**Town & Country Planning Act 1990 (as amended)
Town & Country Planning (Development Management Procedure) (England) Order 2015
Application for Planning Permission for Works or Extension to a Dwelling**

Development Extension to front elevation & conversion of existing rear conservatory.

Location 38 Downview Road Yapton

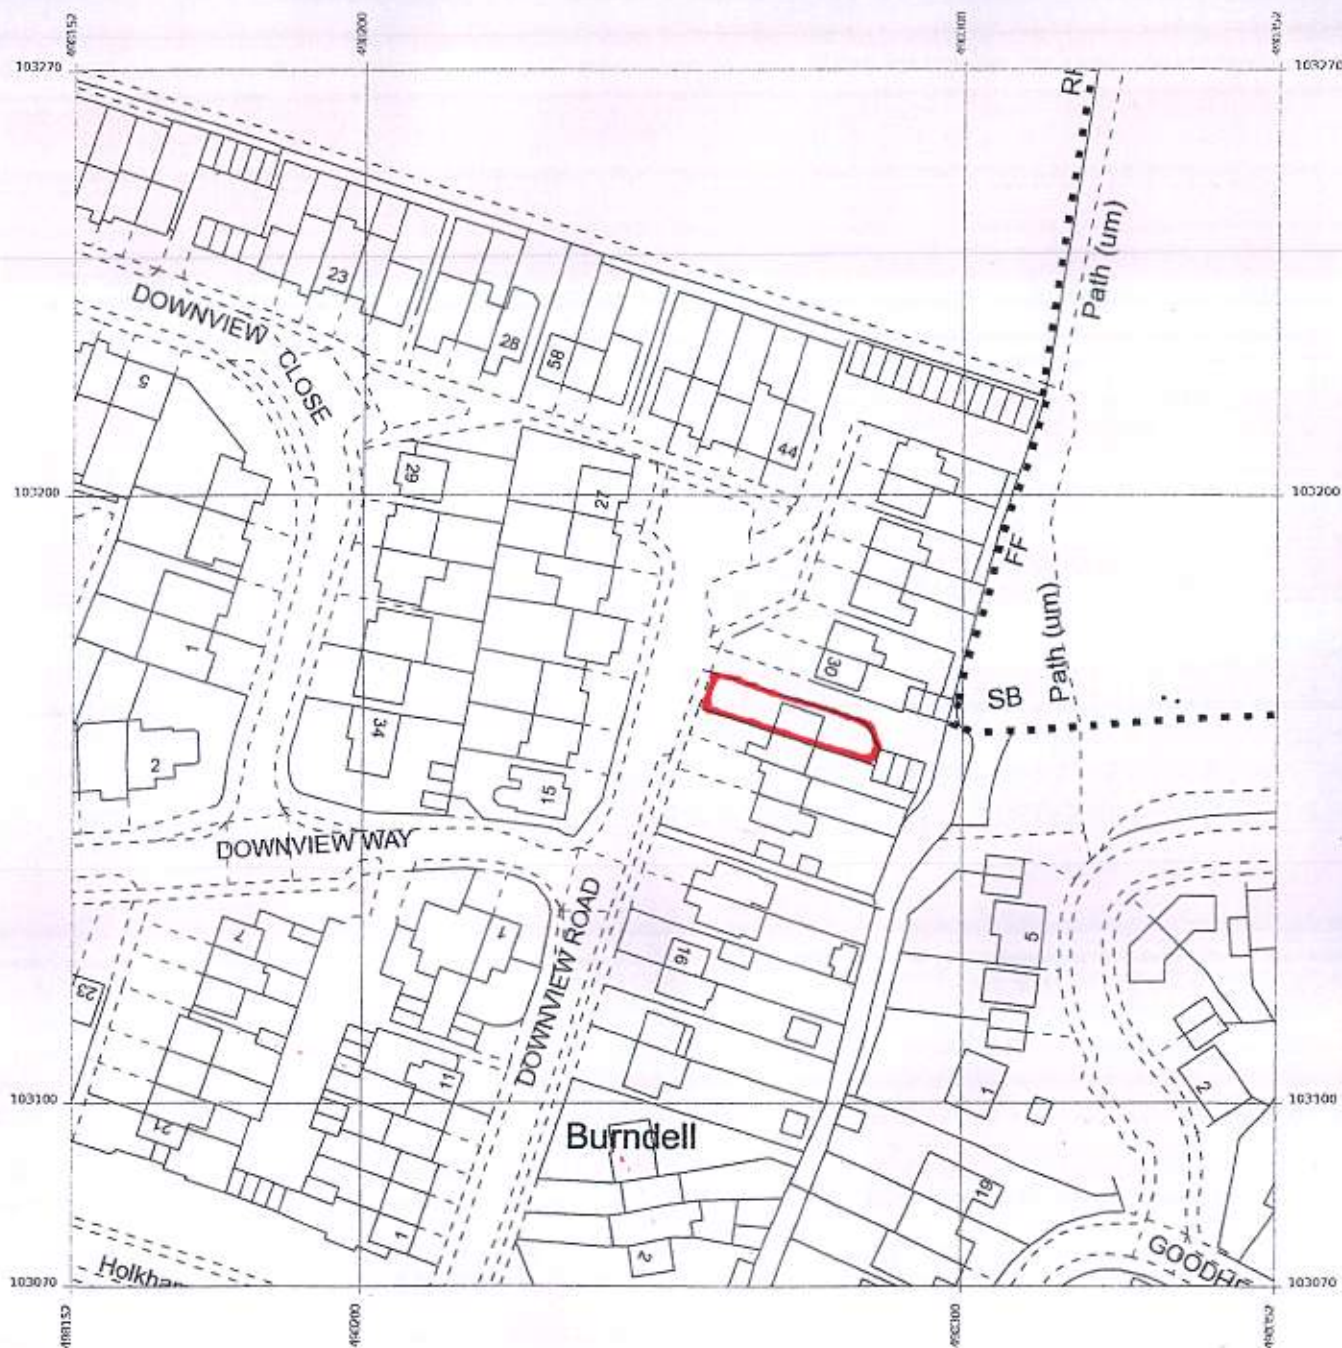
The red edges on both the locaiton and block plans do not accord with the site address on the application form. Please amend accordingly.

On the block plan, please provide dimensions to the site boundaries.
